CITY OF ALBUQUERQUE

March 27, 2017

**RE: Coors Pavilion Subdivision Lot 4 & Portion of Lot 5
9154 Coors Blvd
Grading Plan
Engineer's Stamp Date: 3/1/2017
Hydrology File: G11D069B**

CONCEPTUAL GRADING AND DRAINAGE PLAN

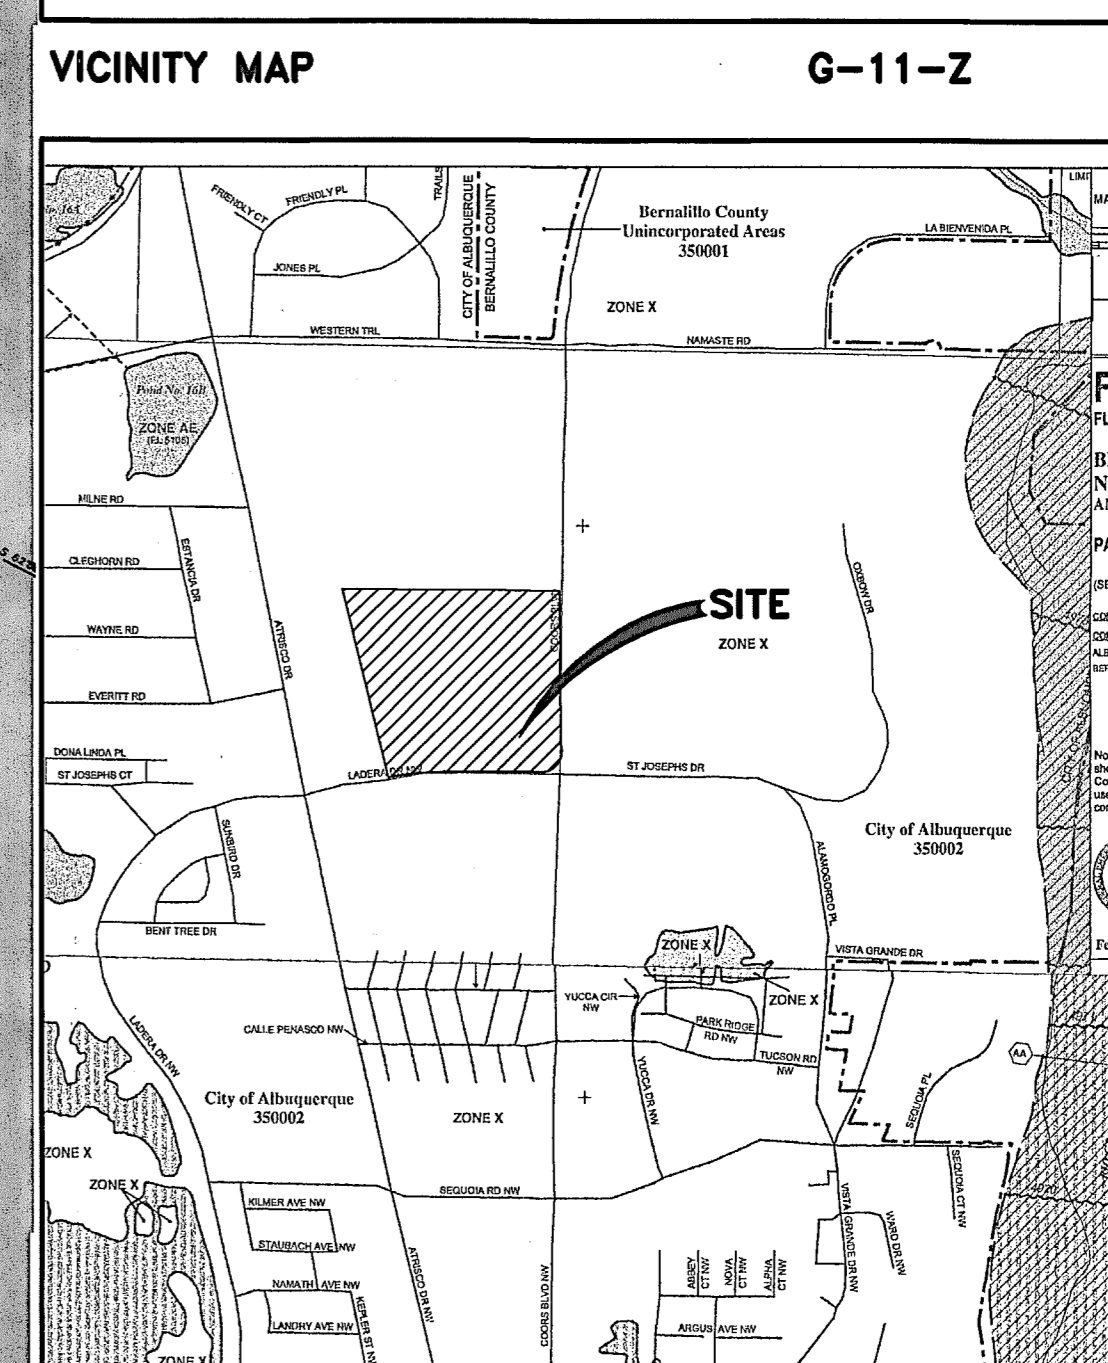
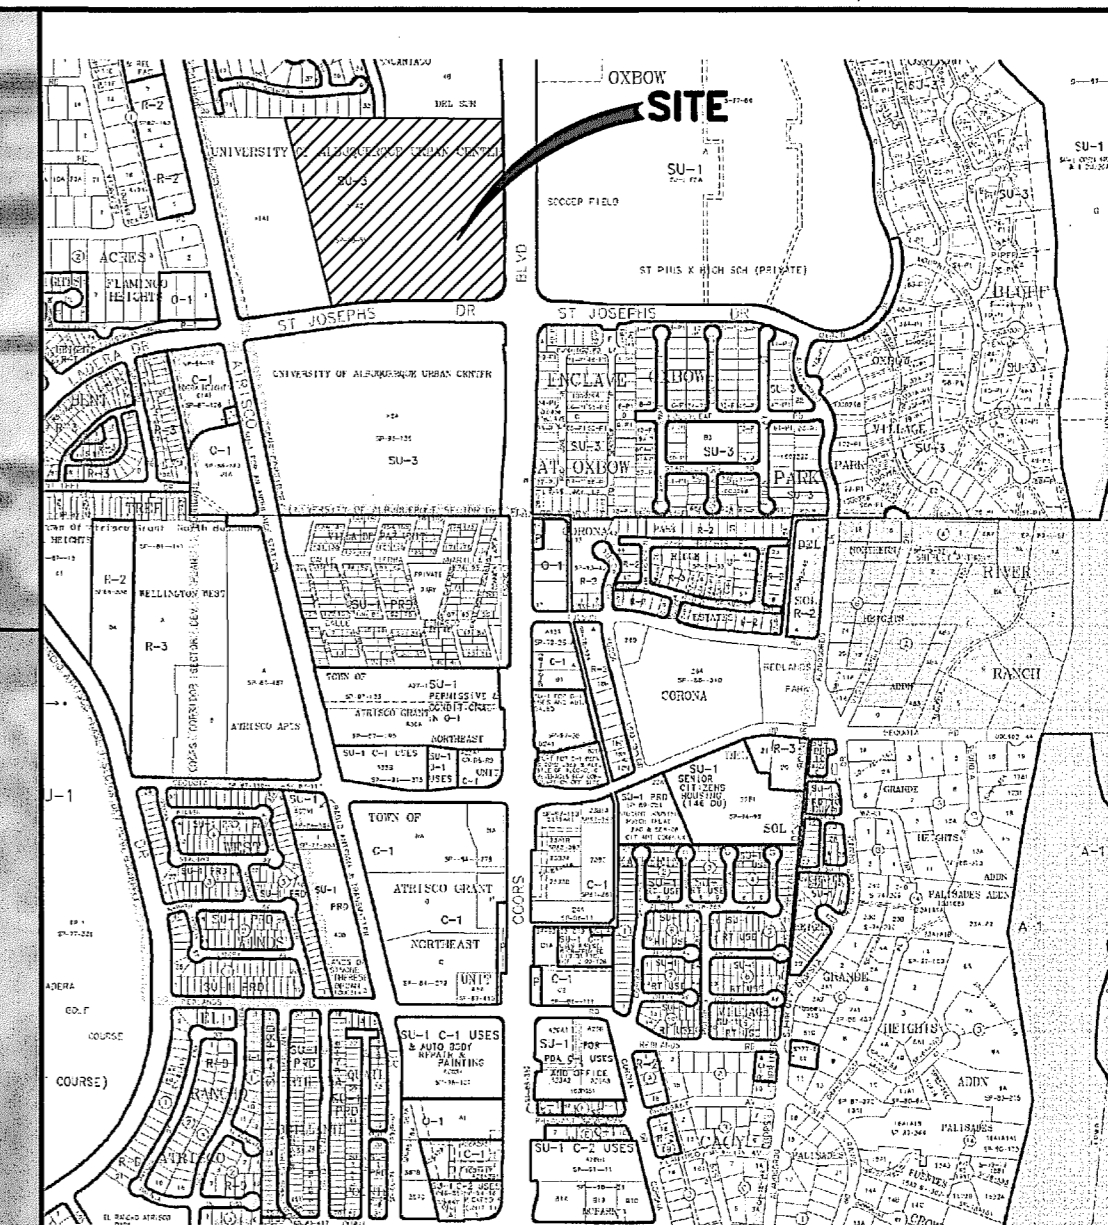
1. Prior to Final Plat, a cross-lot drainage easement will be required for Lot 4 for the benefit of Lot 5.
2. Are either of these lots being developed as restaurants? If so, provide trash enclosure containment and drainage through a grease trap and into the sanitary sewer.
